Engineers Comments Regarding Condition 3 and 4

APPLICATION **LU/109/19/DOC**
NO:

Site Address: Shell Eastfield Worthing Road Littlehampton BN17 6LE

Description of Works: Approval of details reserved by condition imposed under ref LU/314/18/PL relating to Condition No 3 surface water drainage and No 4 flows to watercourses.

Drawing No.
6239-20

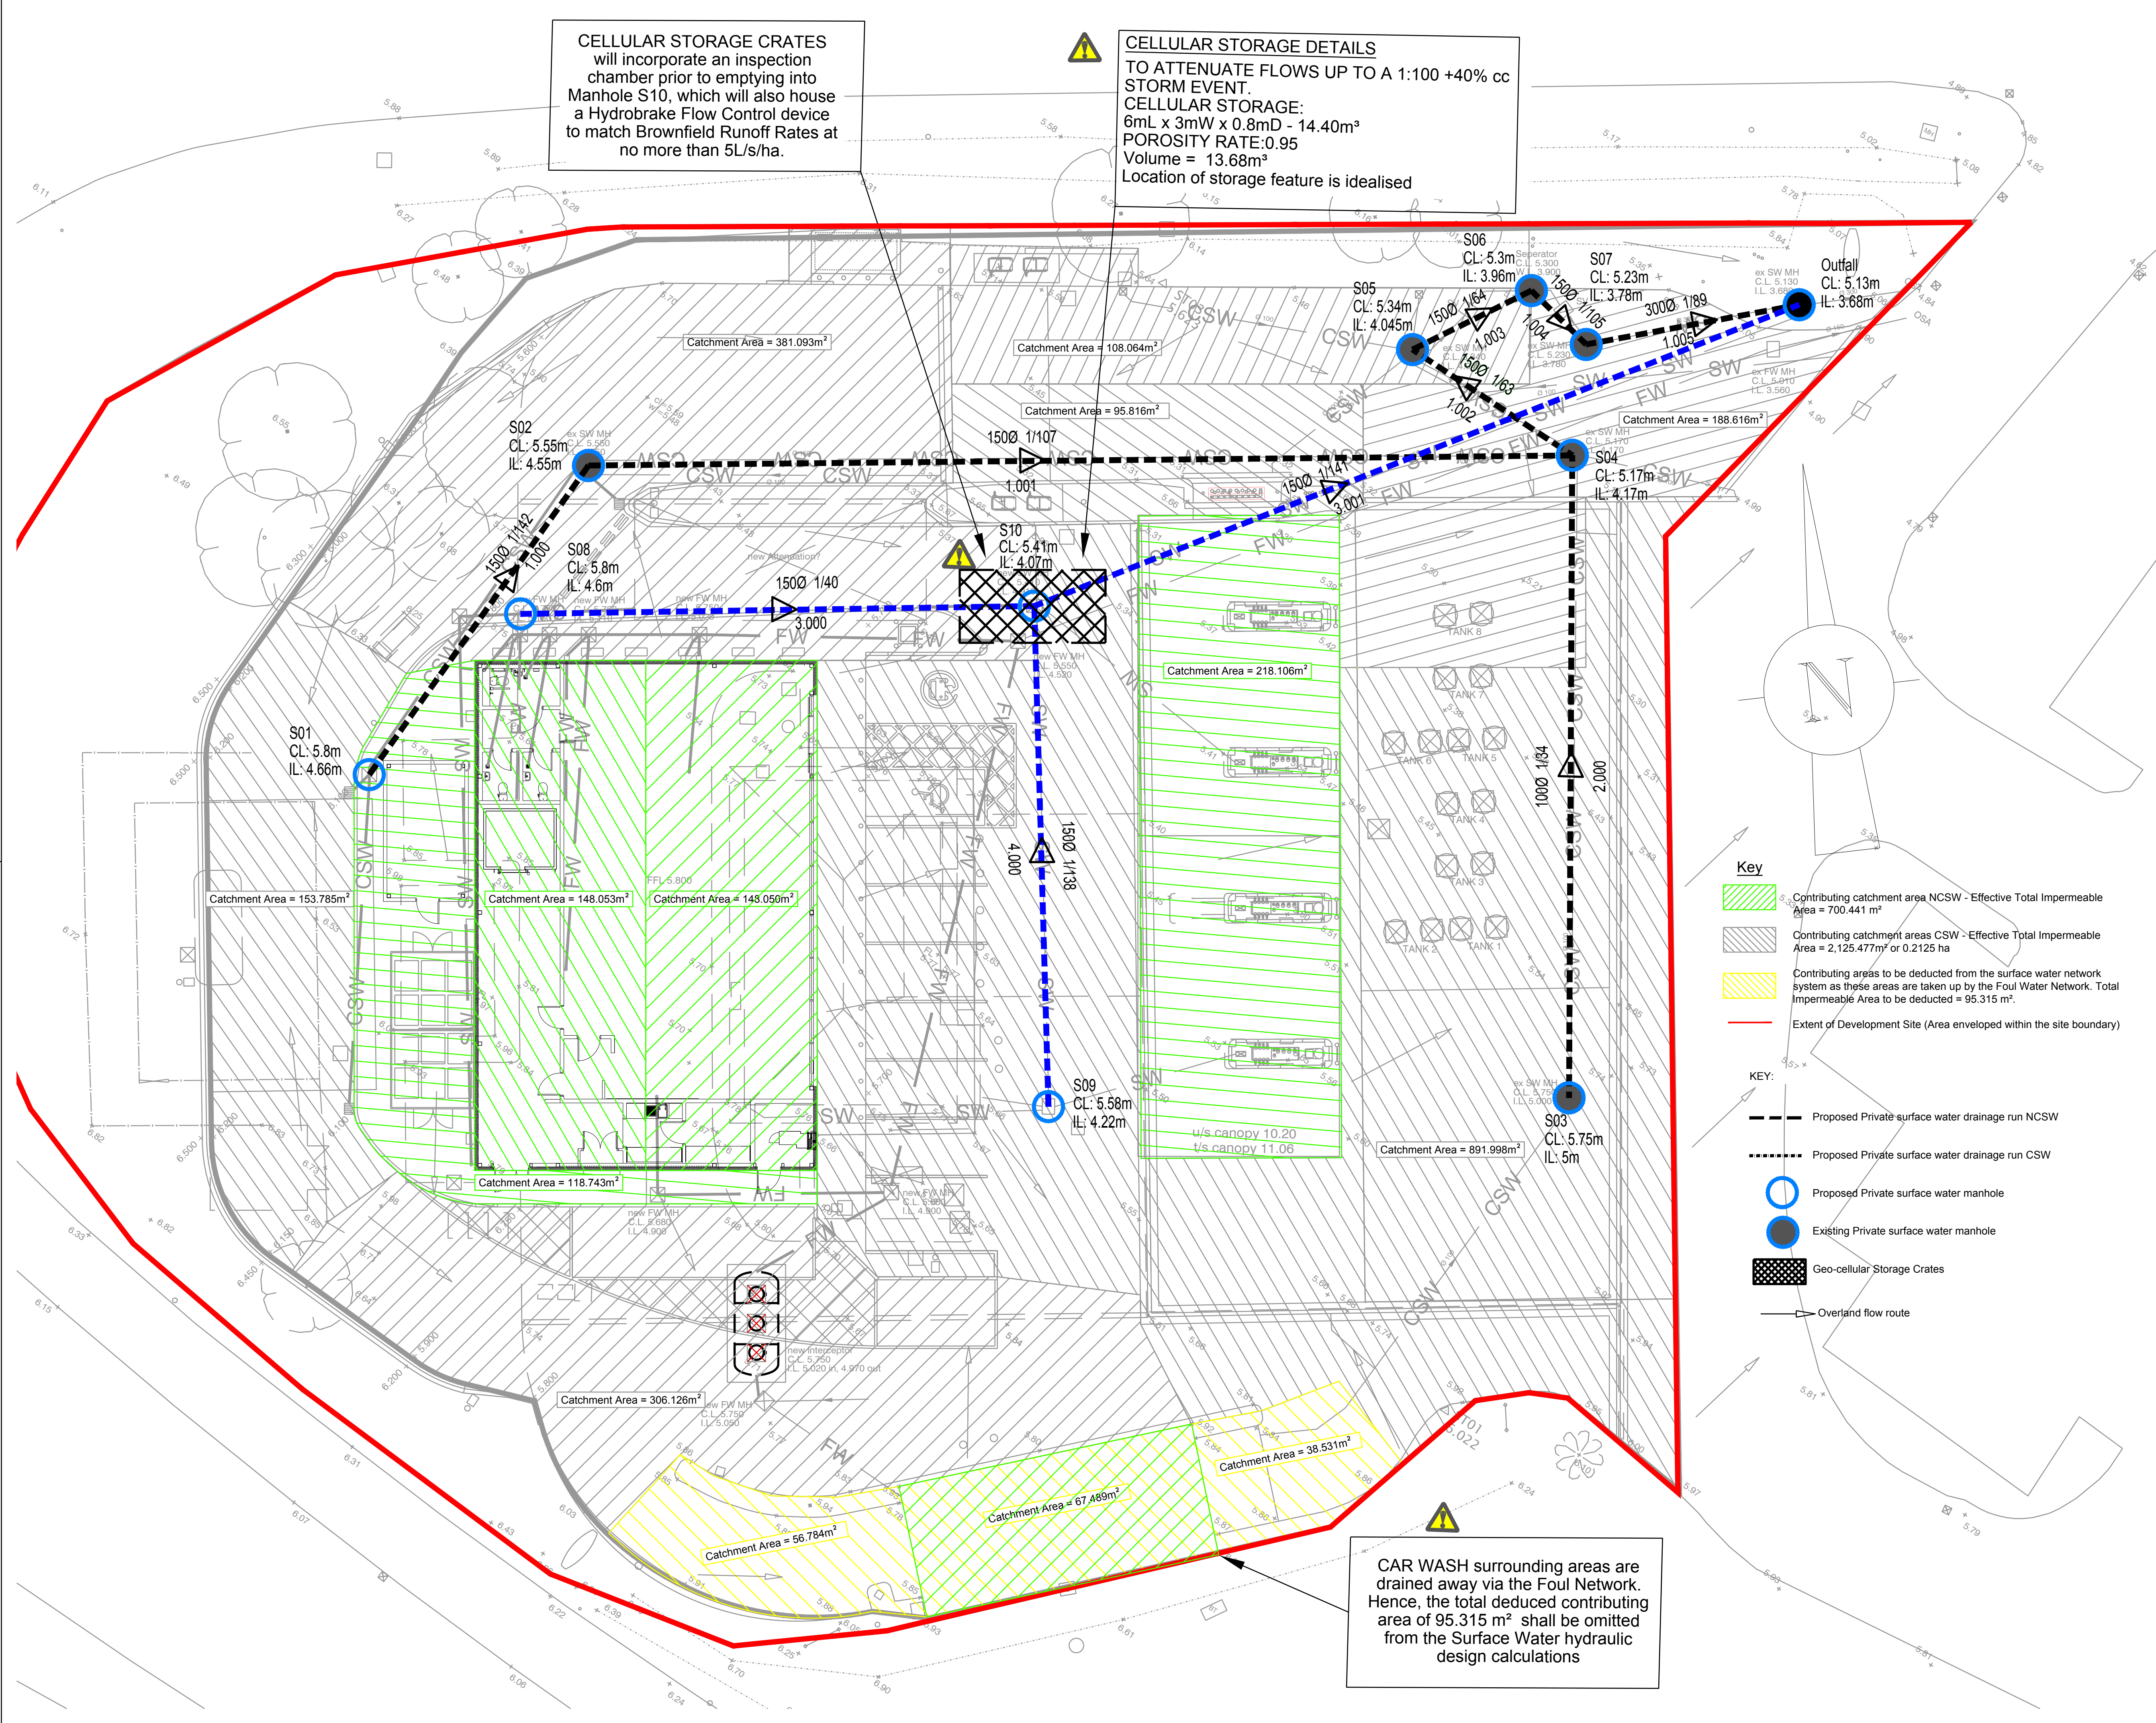
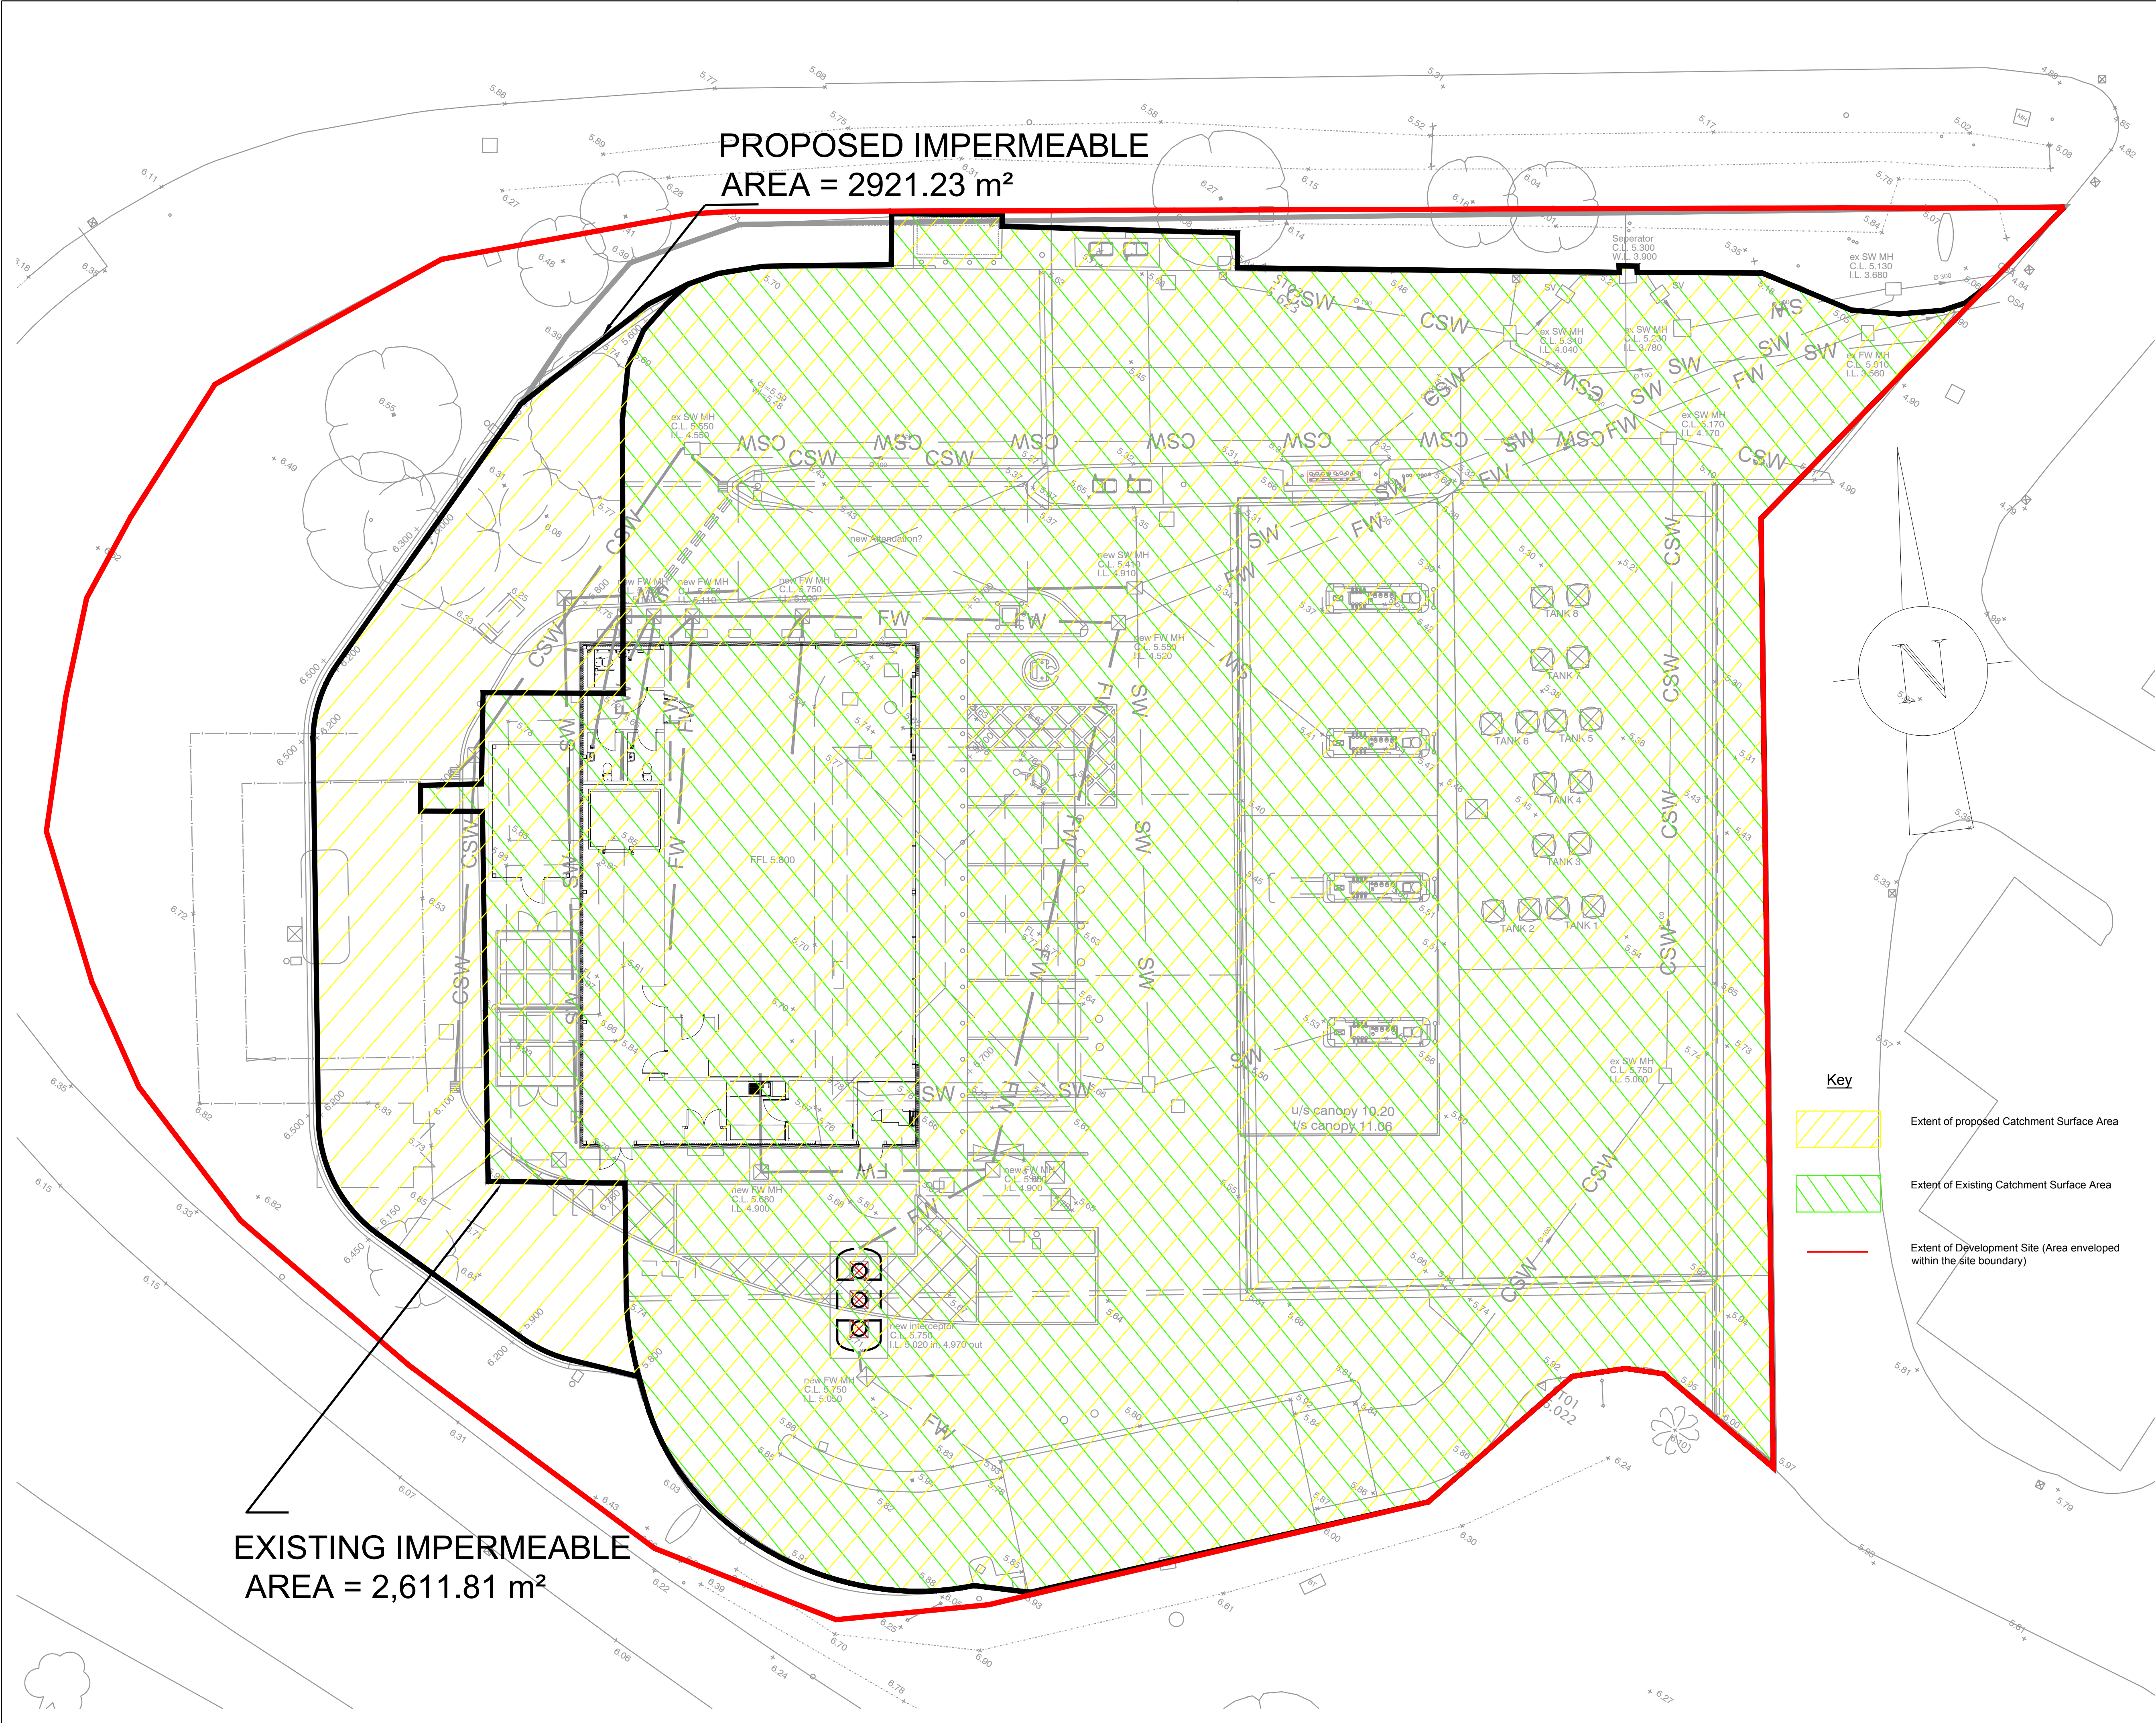
3. The layout plan provided is unclear in terms of differentiation of the two networks. Please revise line types etc.
4. Catchpit manholes should be provided upstream of attenuation tanks.

5. On the layout plan provided everything appears to be ending up discharging to the same location. Yet the text states that the non-contaminated surface water will be discharging to surface water sewer and the contaminated will be discharged to foul sewer. Please confirm and please provide clarity as to whether the proposals are to utilise an existing foul water connection.

Flow Control Device Chamber MH S14 (ADOPTABLE)

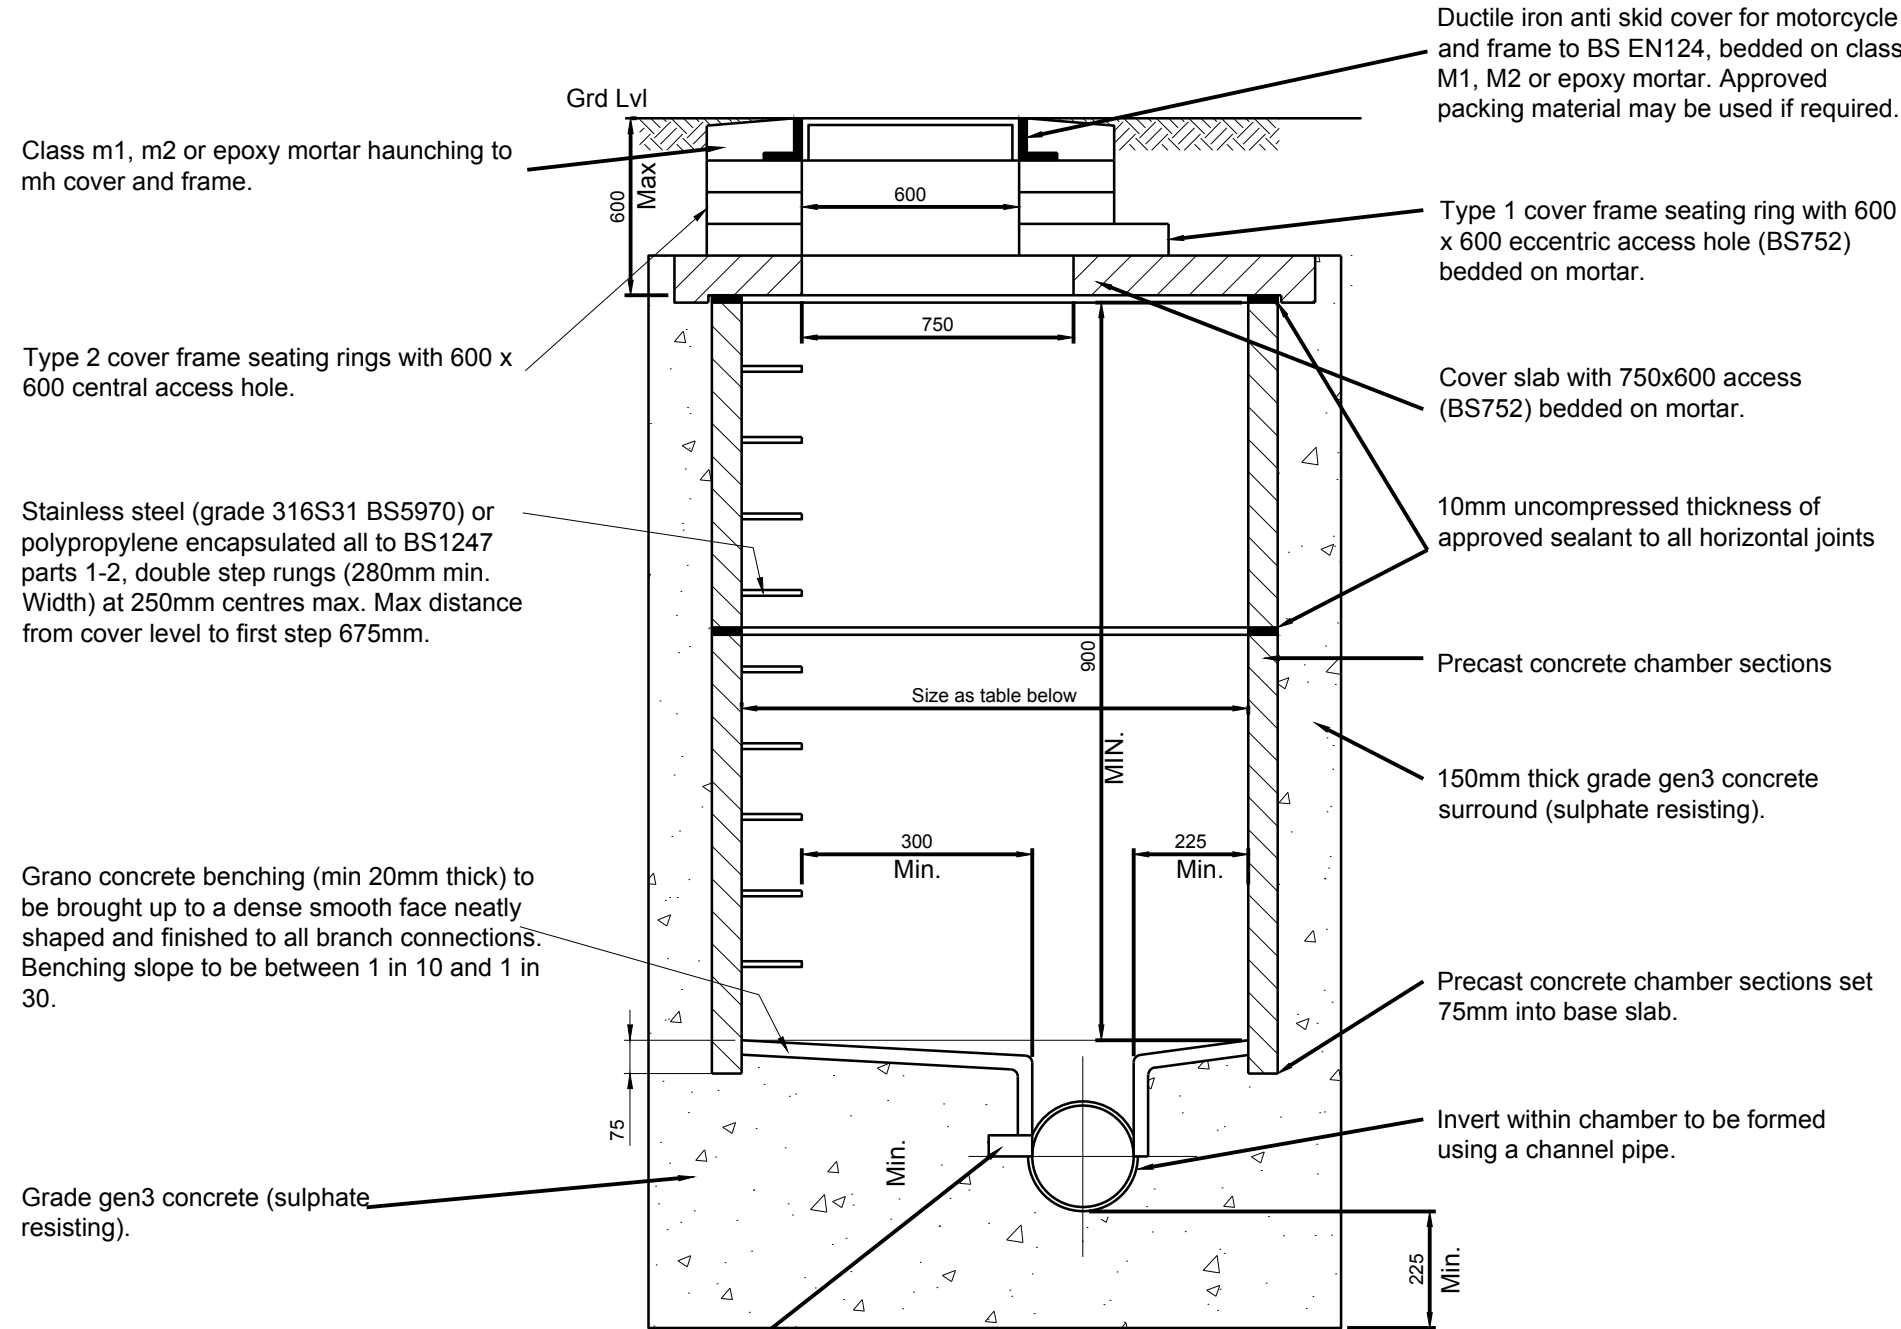
2. Proposed restriction rates from the non-contaminated surface water are too high. Evidence has been submitted which indicate QBar for the existing site is 2l/s yet proposals are for 5l/s. We accept flow restrictions down to 2l/s with appropriate measures provided (use of hydrobrake not orifice and min. 300mm sump) to ensure the risk of blockage is limited, EA guidance of 5l/s is outdated. Please revise design to restrict to 2l/s.
